Your ref: SSD-48225958
Our ref: DOC24/993692

RE: Gundry Solar Farm EIS

Thank you for the opportunity to review the documents associated with the proposed Gundry Solar Farm. Biodiversity, Conservation and Science (BCS) have reviewed the Environmental Impact Statement (EIS), including the Biodiversity Development Assessment Report (BDAR) provided as Appendix 7 and have the following comments:

**FIGURE 6.17**  
Hydrological Context

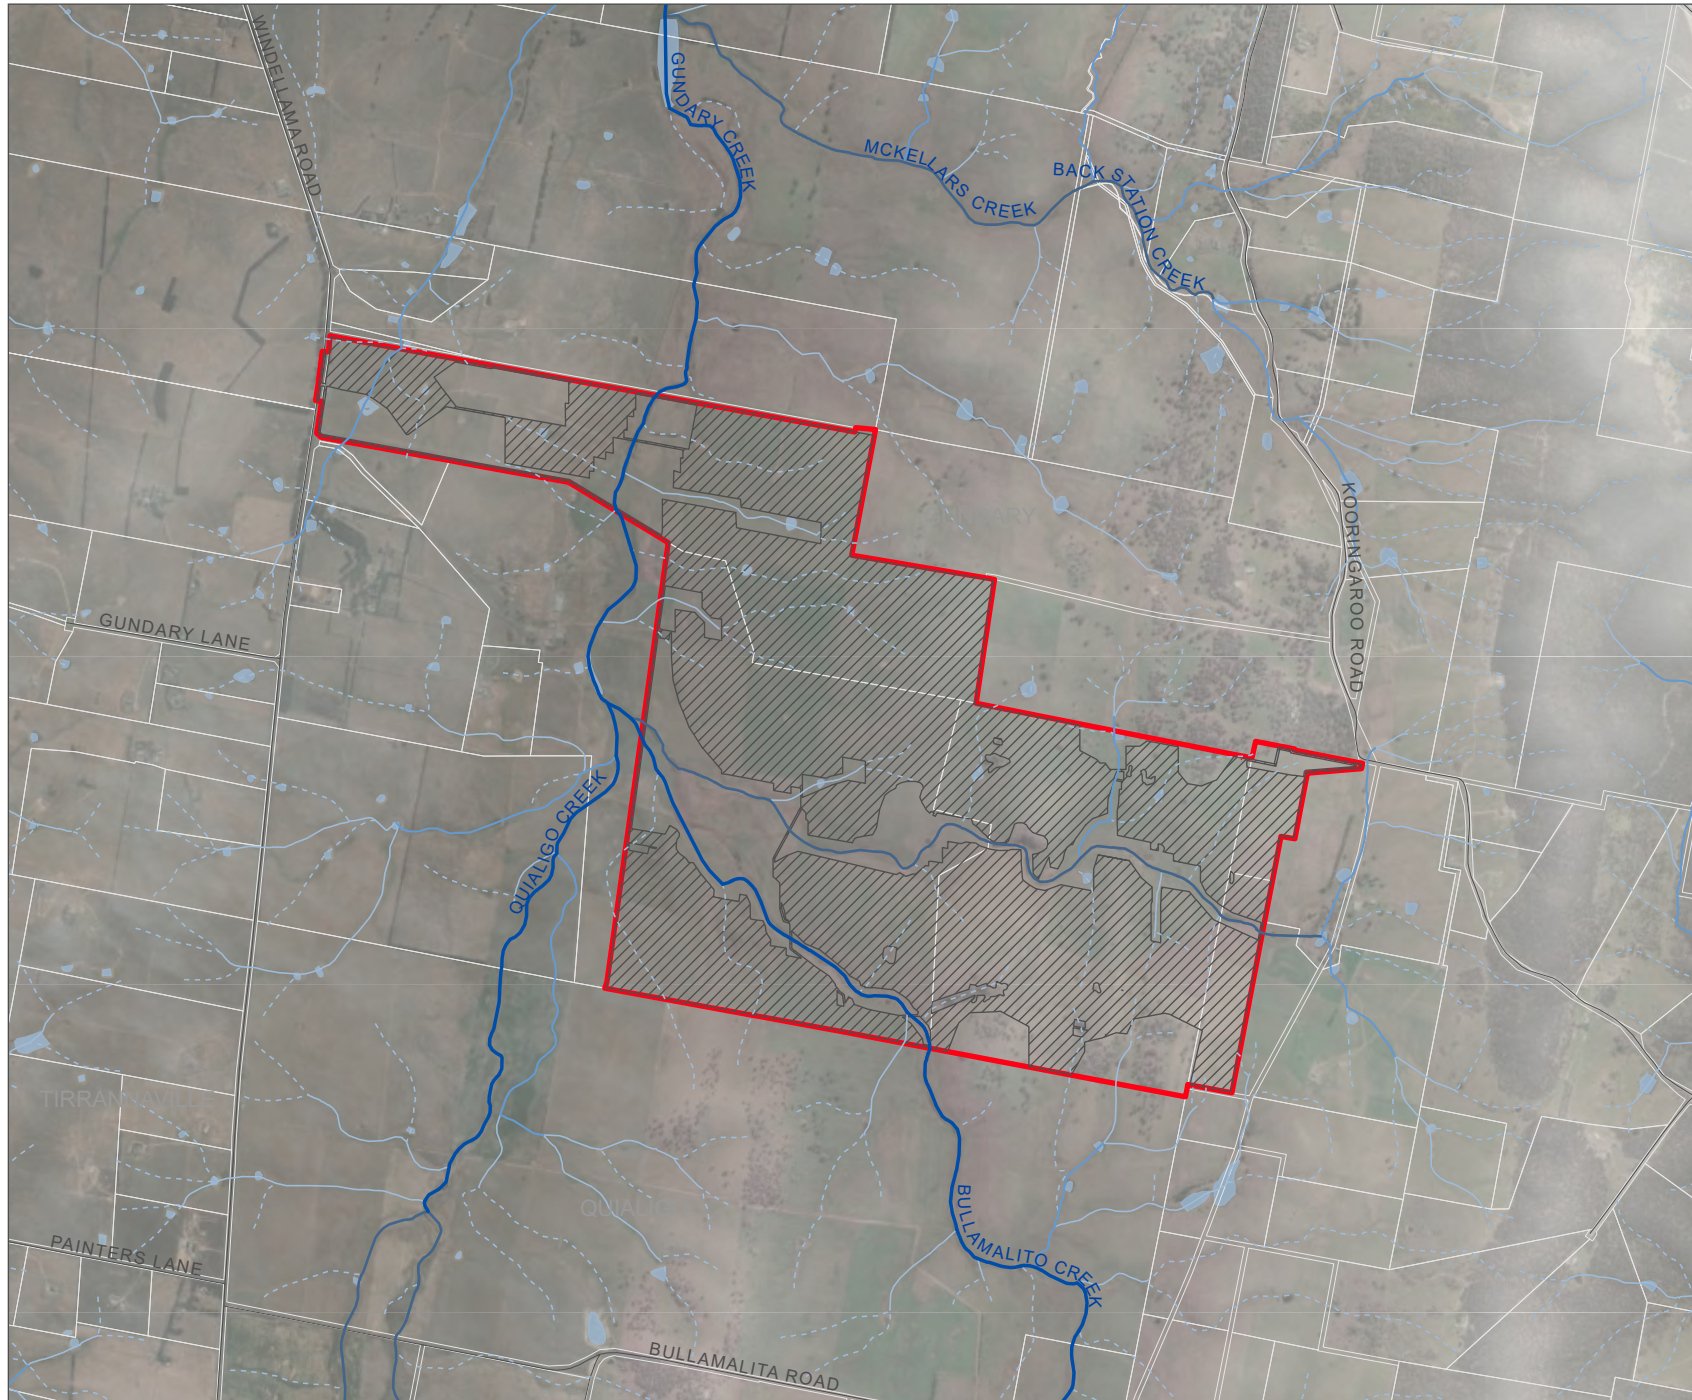
The information provided identified a substation to the west near Windellama Road which is proposed to be built over an unnamed ephemeral creek. The flood maps provided with the FIRA show that this creek carries flood water during all design events and the proposed substation will be affected by flooding and has the potential to influence flood behaviour. Comparison of pre- and post-development modelling results (Figures C.1-C.7 in Appendix C) show that flood water is re-directed east and west of the new substation. The re-direction of flood water around the eastern side of the substation raises questions around localised erosion and off-site flood impacts which the assessment does not address.

The FIRA presents an assessment of existing creek stability and condition, and refers to an Operational Environmental Management Plan (OEMP) to be developed to address potentially adverse impacts on the receiving environment during the operational phase. Consistent with previous advice, it is recommended that this OEMP includes measures to minimise erosion and demonstrate sustainable outcomes for the waterways. This will ensure the preservation of healthy waterways in terms of water quality and quantity across the project site including measures to manage erosion impacts.
